Reference No:	<b>2024/62/90694/W</b>
Site Address:	21, Benomley Crescent, Almondbury, Huddersfield, HD5 8LT
Description:	Erection of single storey extension to side
Recommending Officer:	Laura Yeadon

## HOUSEHOLDER DELEGATED REPORT

<b>Application Number</b>	2024/90694
<b>Location</b>	21, Benomley Crescent, Almondbury, Huddersfield, HD5 8LT
<b>Proposal</b>	Erection of single storey extension to side
<b>Publicity end date</b>	26 <sup>th</sup> April 2024
<b>Number of representations received</b>	None
<b>Kirklees Local Plan Allocation/Designation</b>	Unallocated
<b>Extension to Time (EoT)</b>	No
<b>Recommendation</b>	Conditional Full Permission

Proposed Floor Plan

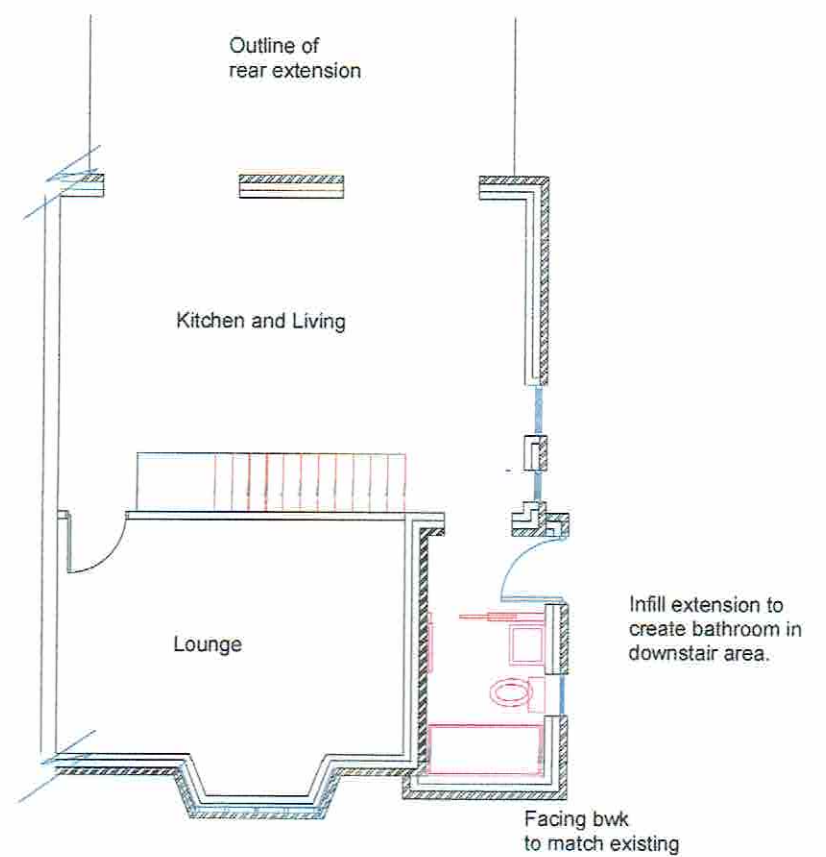
<b>YES / NO</b>	<b>SUMMARY</b>
Negotiations/Amendments during course of application	Yes	Requested extension was set back to lie flush with the front elevation of the property – amended plans received 16.4.2024
Parish/Town Council comments sought	No	
Planning History	None	
Consultations required	None
